Reference: 3/2023/0903 - 9 Moor Field, Whalley, BB7 9SA

I am writing to lodge an objection to the above planning application.

Ref. FS-Case-570018056 planning application 3/2023/0903

Proposed Front Elevation (1)

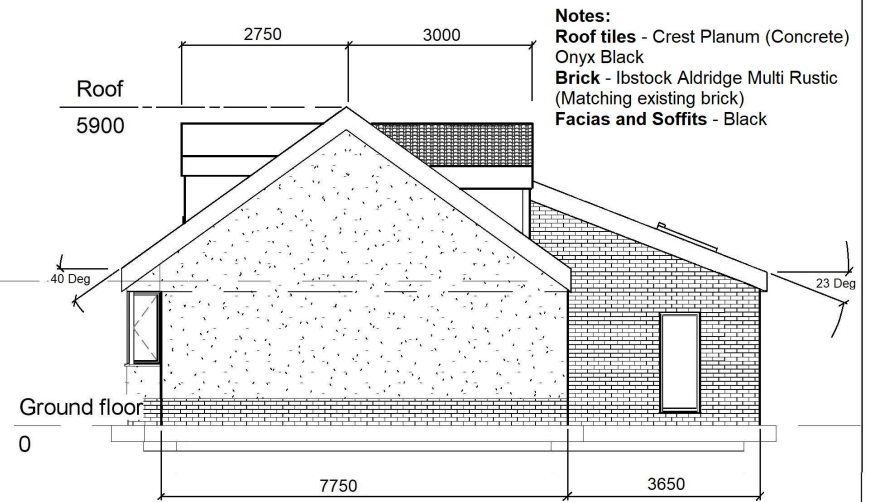
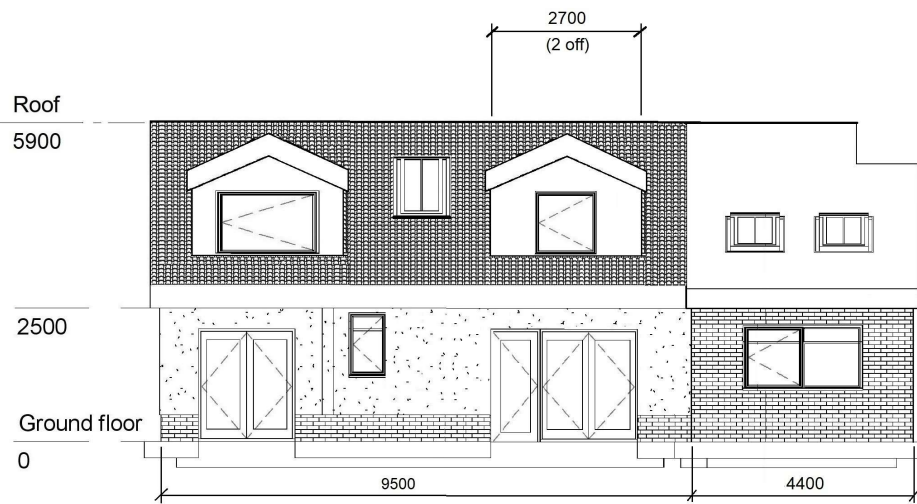
3. The new application – 3/2023/0903 further increases the opportunity for properties being overlooked with the addition of a third front dormer and to the rear, an additional Velux-type window (which does not appear to be mentioned in the application, only shown on the proposed elevations) between the two rear dormers. To the rear, when compared to the original layout, the result will be an additional five windows overlooking the gardens and the rear of the houses which is not acceptable. This bungalow has had more than enough redevelopment with the two earlier applications.

Proposed Rear Elevation (2)

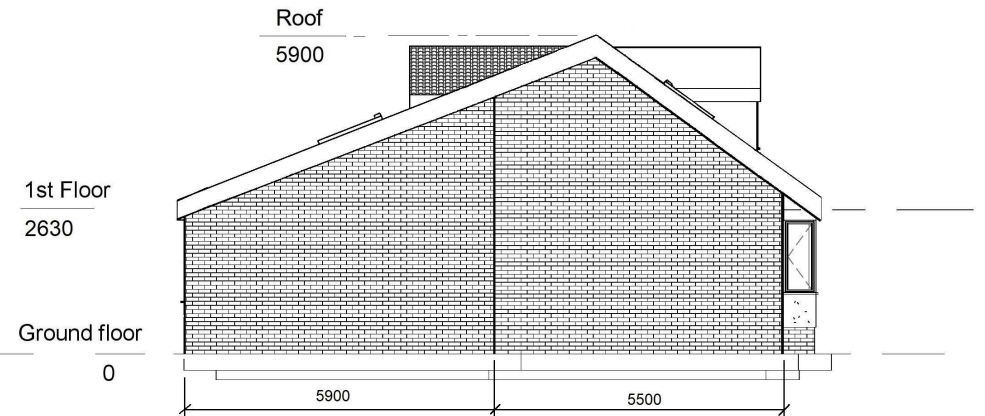
1. Both the increase in height and number of glazed openings very significantly increase the overlooking and loss of privacy to our [REDACTED], as there wasn't any previous opportunity for overlooking;
